DRB Application No.: <u>04DRB-01020 (SBP)</u>	Project # <u>1003126</u>
Project Name: <u>MRGCD MAP 29</u>	Phone No.: <u>899-3570</u>
Agent: <u>Advanced Engr. & Consulting</u>

Project Number: 1003126
Application Number: 04DRB-01020

Tract 45-B, MRGCD Map 29

SUBJECT: EPC CONDITIONS FOR PROJECT 1003126

SITIO BUSINESS PARK SITE PLAN FOR BUILDING PERMIT			
DRAWING:	DRAWN BY:	DATE:	SHEET #
200355-ST.DWG	SHH	11-10-03	1 OF 5

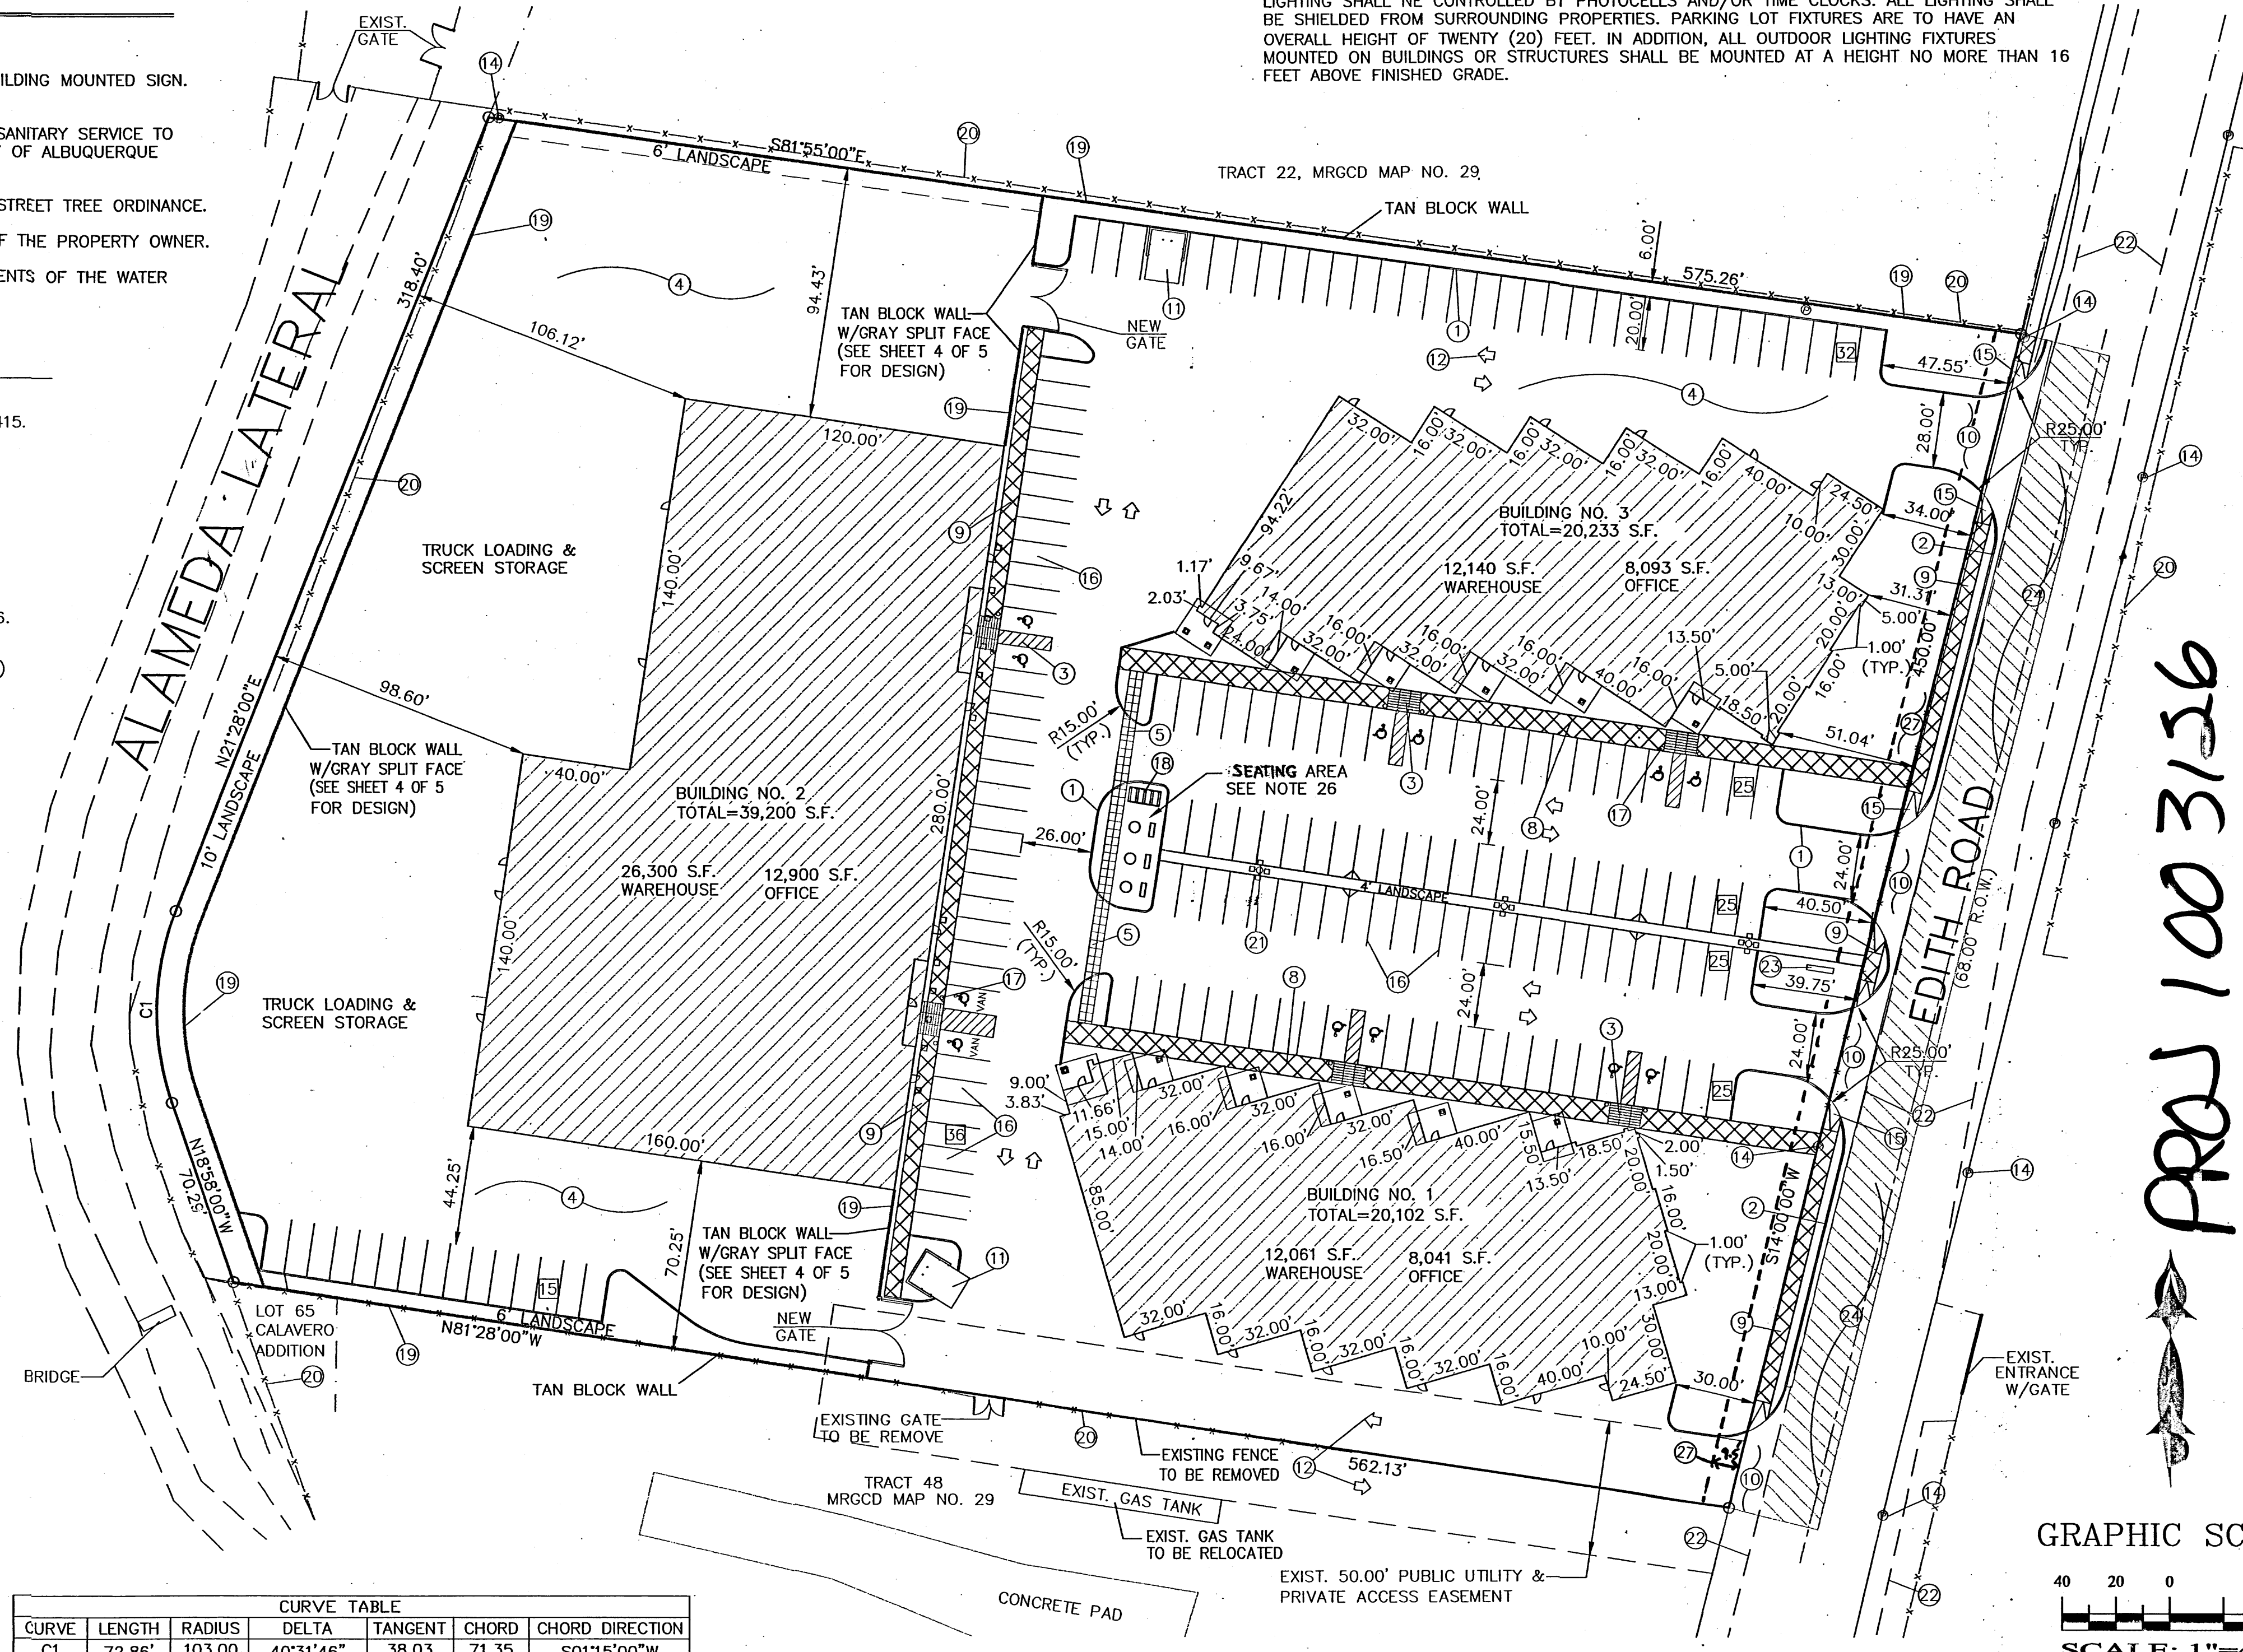
Condition #3: A minimum of 7 bicycle spaces shall be provided. Bicycle racks shall be conveniently located near building entrances but not within pedestrian pathways or landscape areas.

A bike rack with 7 spaces is shown, but it is shown within the landscape area. This element must be shown in an area that is "not within pedestrian pathways or landscape areas".

LANDSCAPE

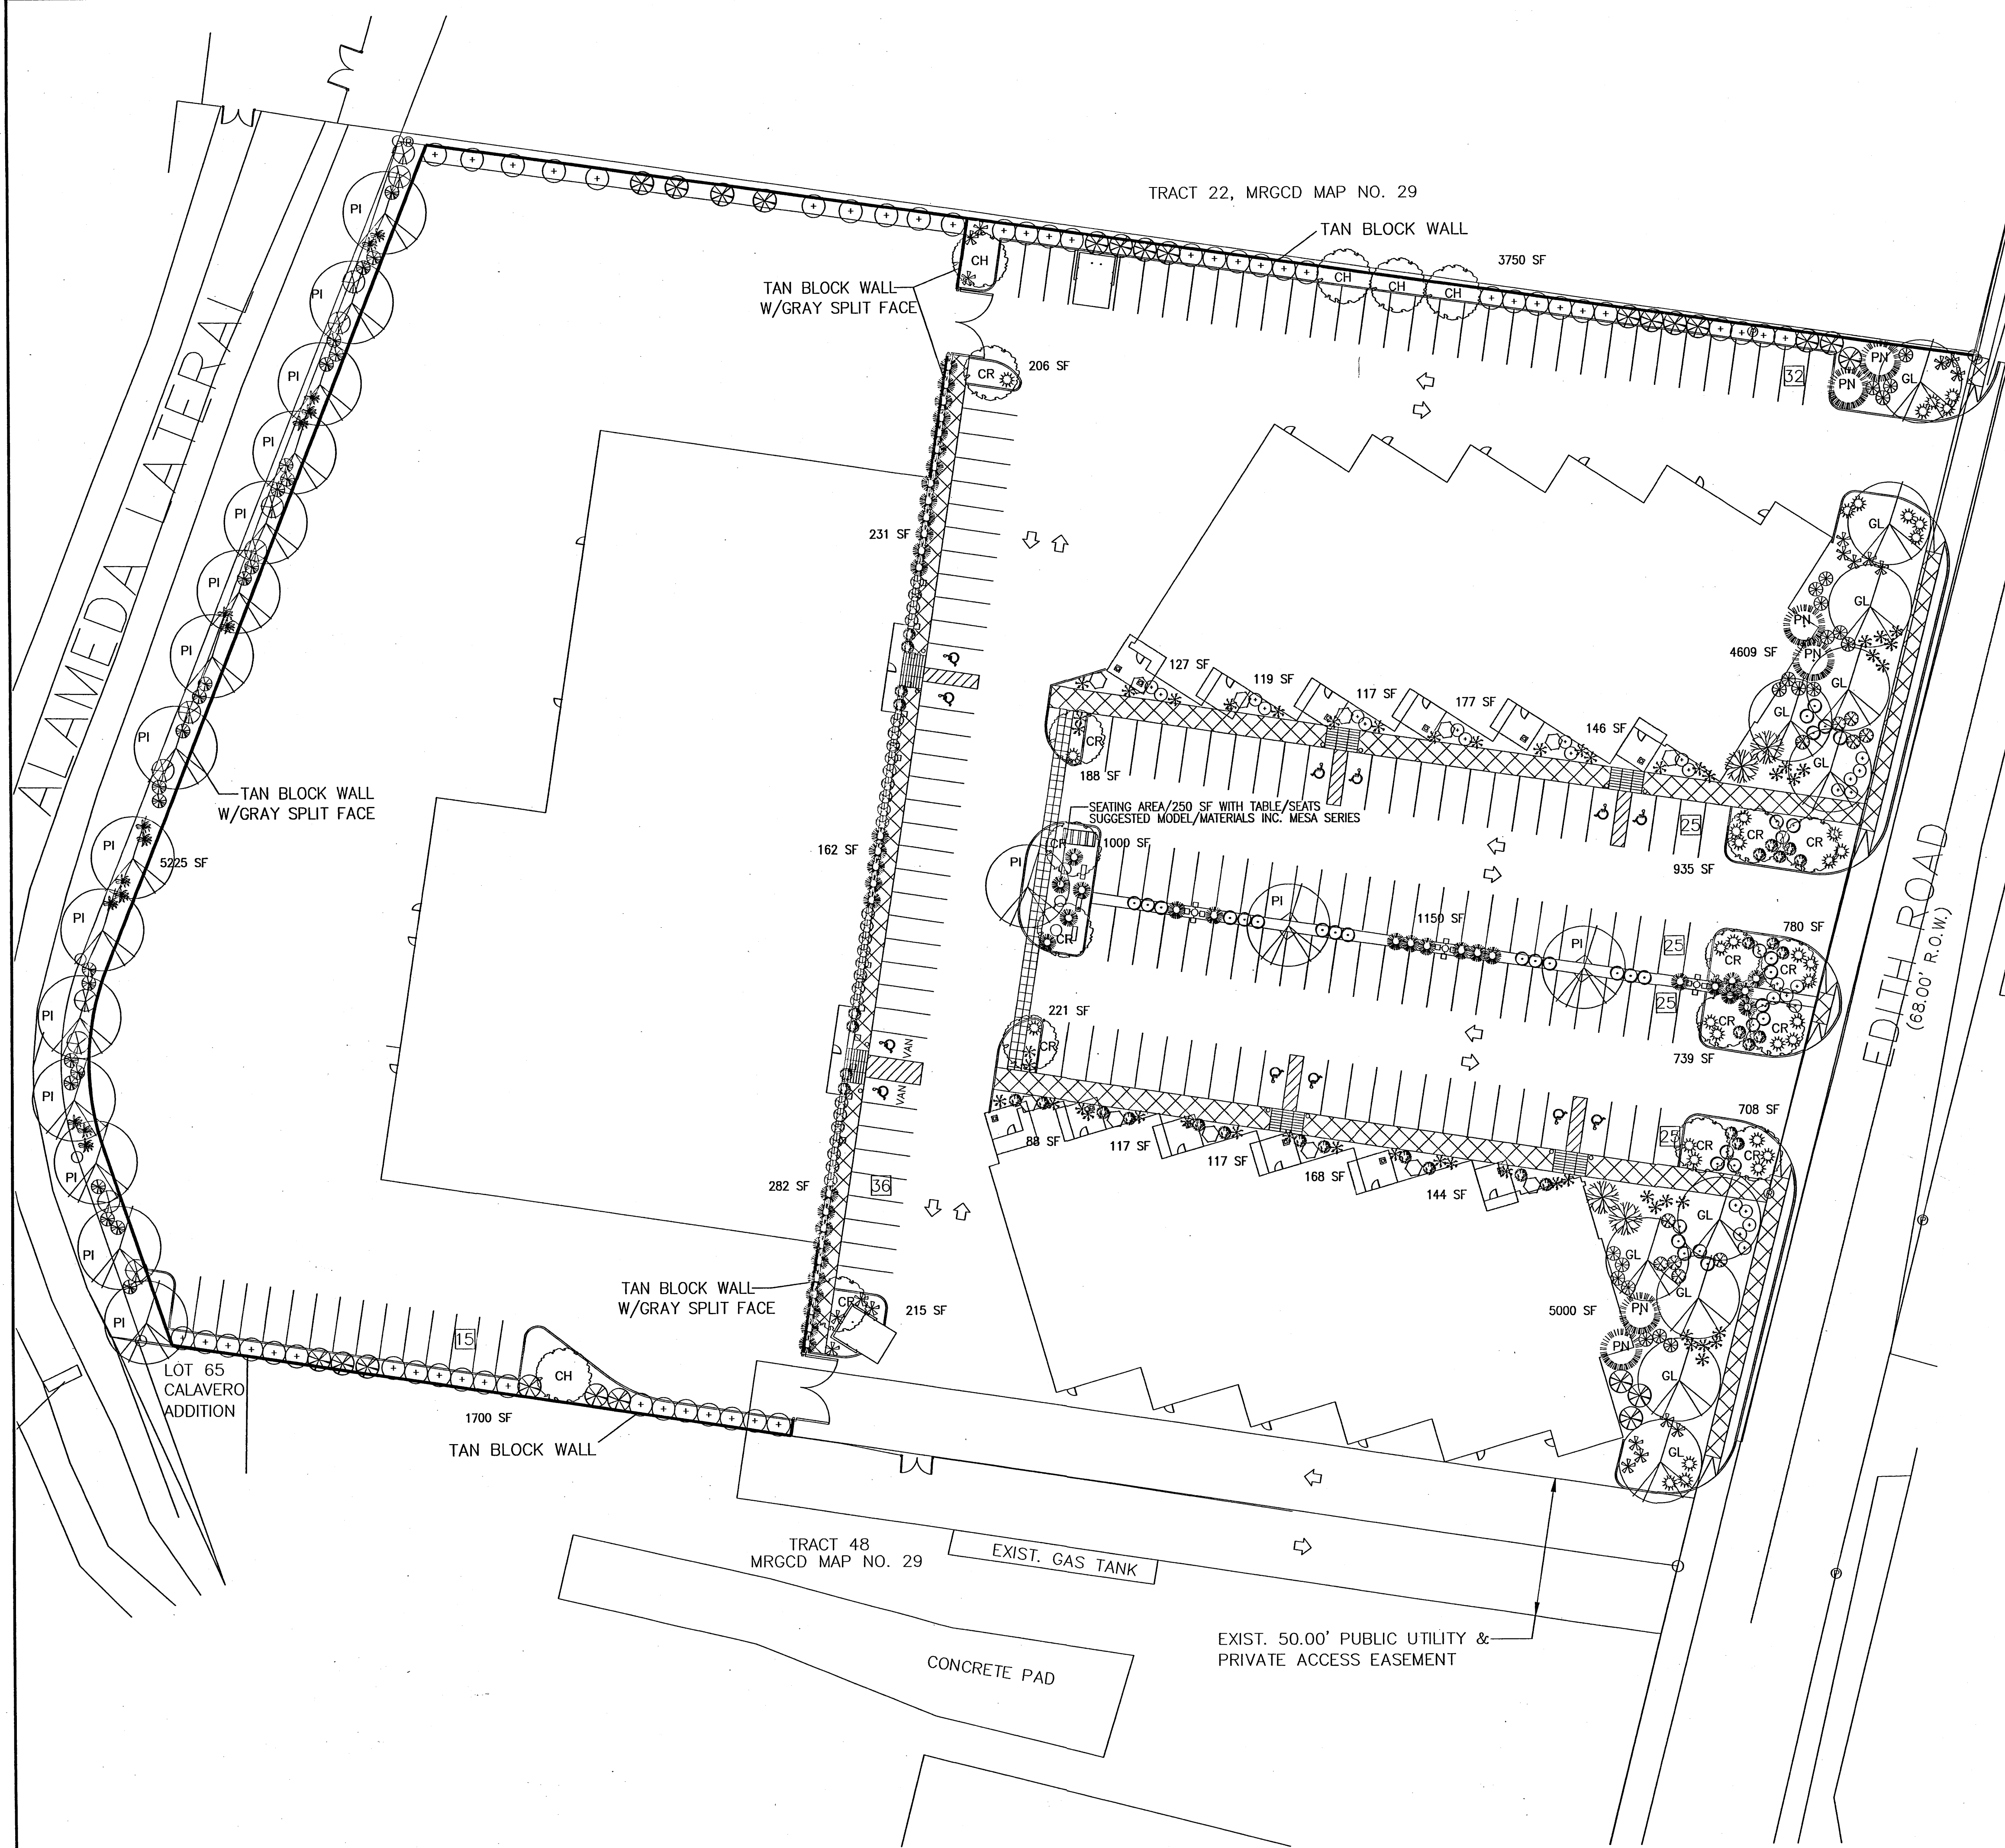
Condition # 6: The Landscape Plan shall provide adequate street trees as required by the Street tree ordinance by providing a total of 15 shade trees along Edith Boulevard. A street tree is required to provide a shade canopy and be planted within 20-feet from the edge of the street (Street Tree ordinance, Section 6-6-2-3, Definitions)

Staff counts 14 trees that meet this definition. One additional shade tree could be added to the northern, landscaped end aisle to fulfill this requirement.

Condition #7: The entire western side of the site shall be planted with trees to ensure both screening and aesthetics to the neighbors across the Alameda Lateral.

Ten Desert Willows are shown for this area. The condition states the "entire western side" of this site shall be planted with trees to provide screening and aesthetics. Staff recommends following the street tree requirement of one tree for every 30 feet of frontage. In this case, that would require the placement of 5 additional trees. These trees should be pines to provide the year round screening of a non-deciduous tree. In addition, staff recommends that more substantial trees be used for this site in place of desert willows, since the requirement is to provide screening and desert willows do not reach great heights or dense leafing patterns. Any of the other deciduous trees on the current plant list are acceptable, i.e. Pistache, Honey Locust, or Hawthorn.
